From: Graham Evans
Sent: 03 November 2011 09:03
To: Planning.Responses
Subject: FW: Planning Consultation on: LU/245/10/

APPLICATION NO: LU/245/10/

Description of Works: Repositioning of security fencing to boundary of site and security lighting to access road to land on the west bank of the River Arun and construction of additional pontoon moorings.

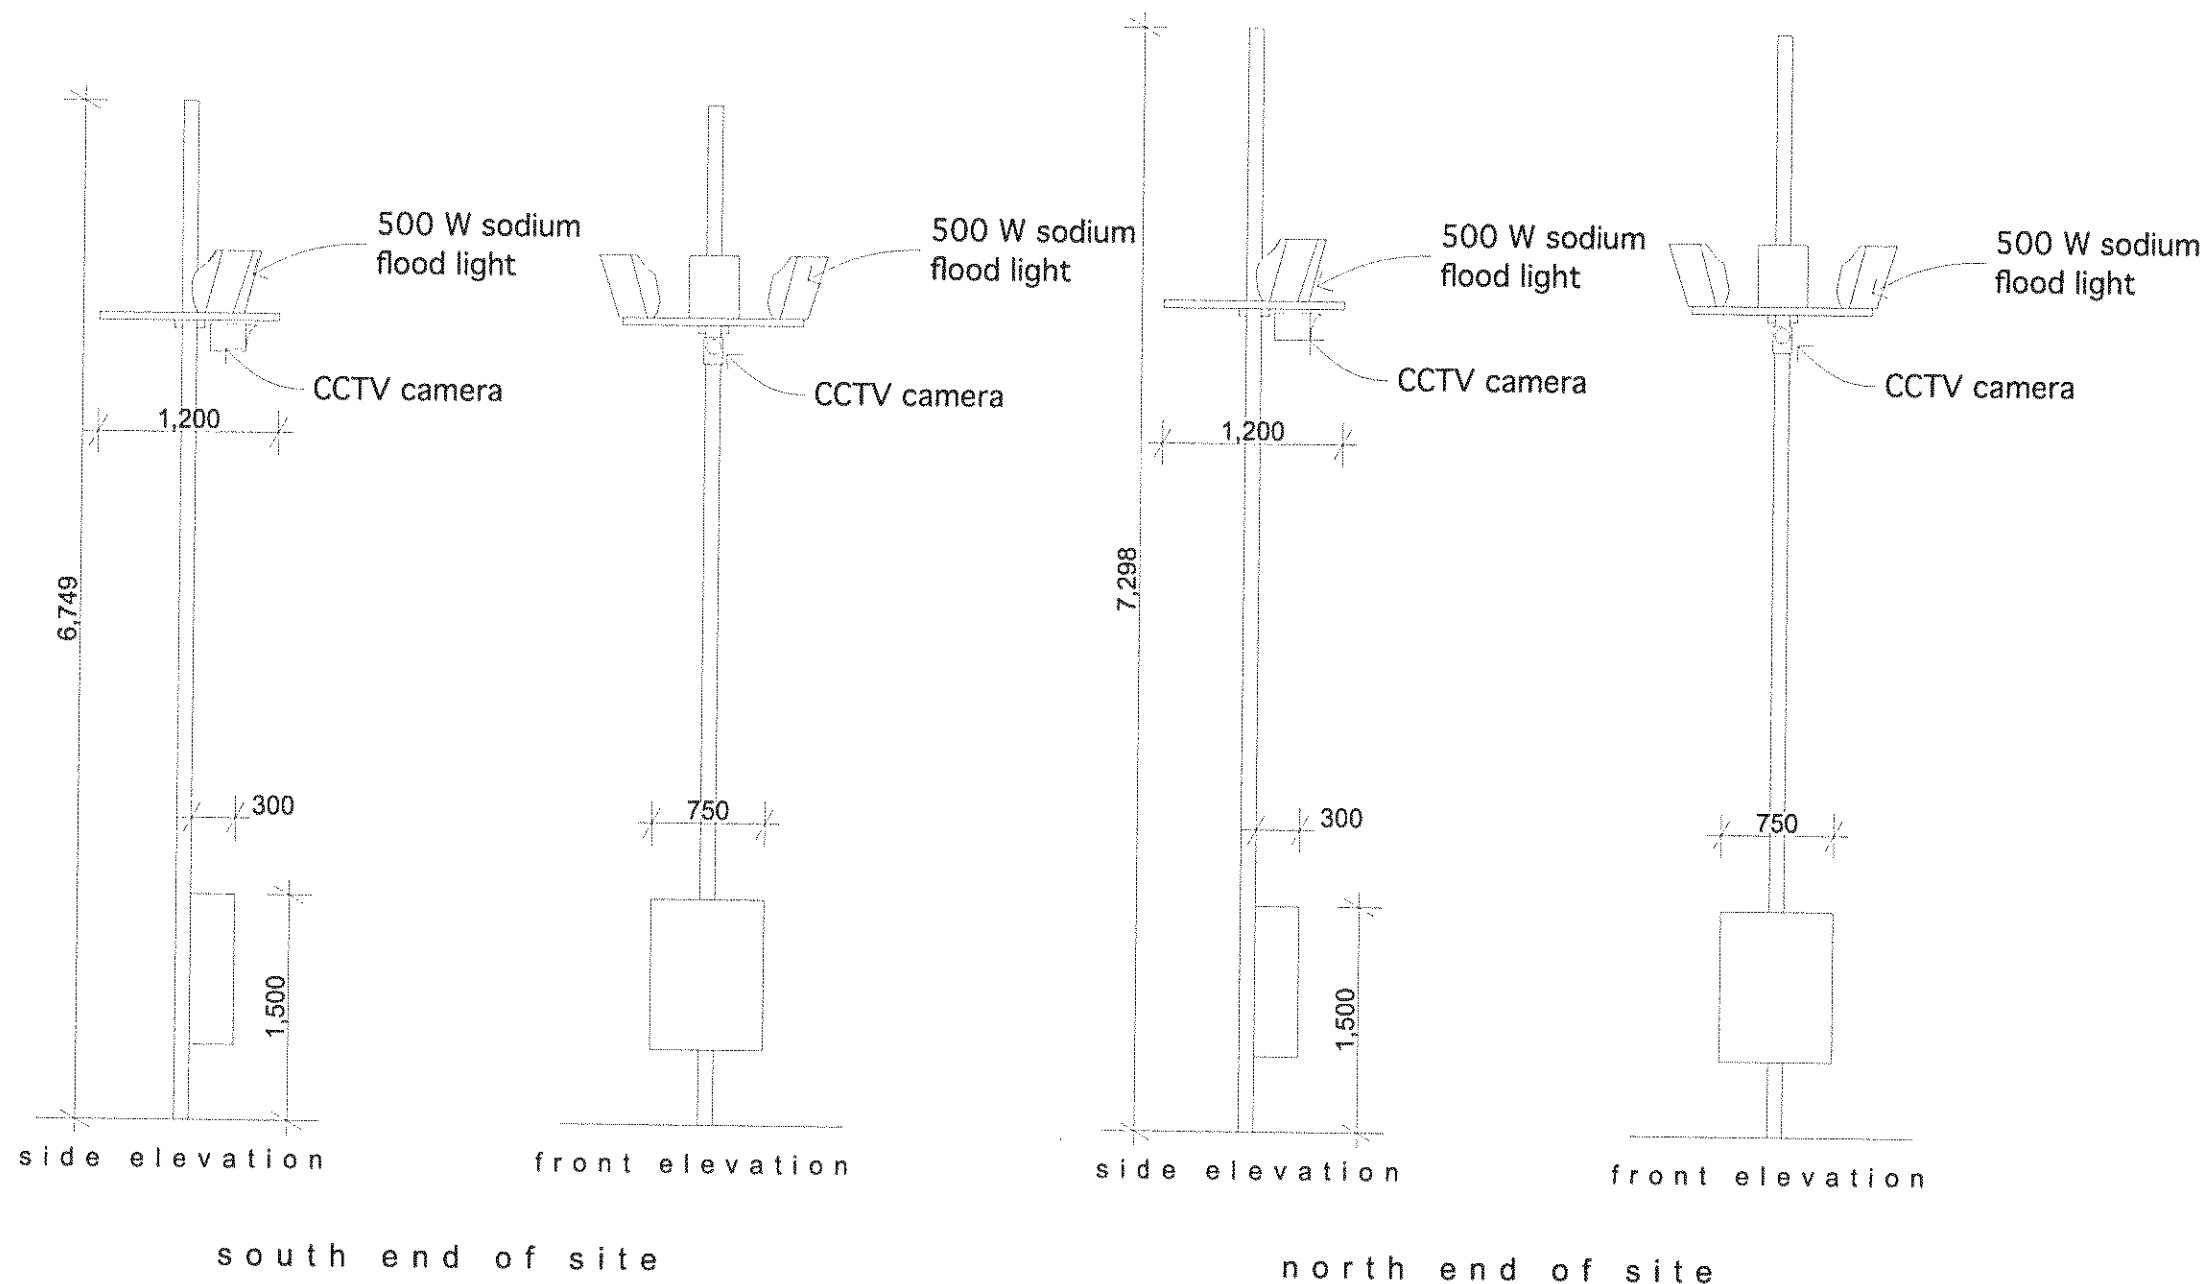
No EH objection subject to imposition of condition EHL2 in respect of security lighting. A copy of the ILE Guidance is attached, I would suggest that the application site falls within Environmental Zone E2 - "Low district brightness area" (p3).

A report should be obtained from a suitably qualified (ILE) lighting engineer confirming that the proposed scheme will comply with this Guidance.
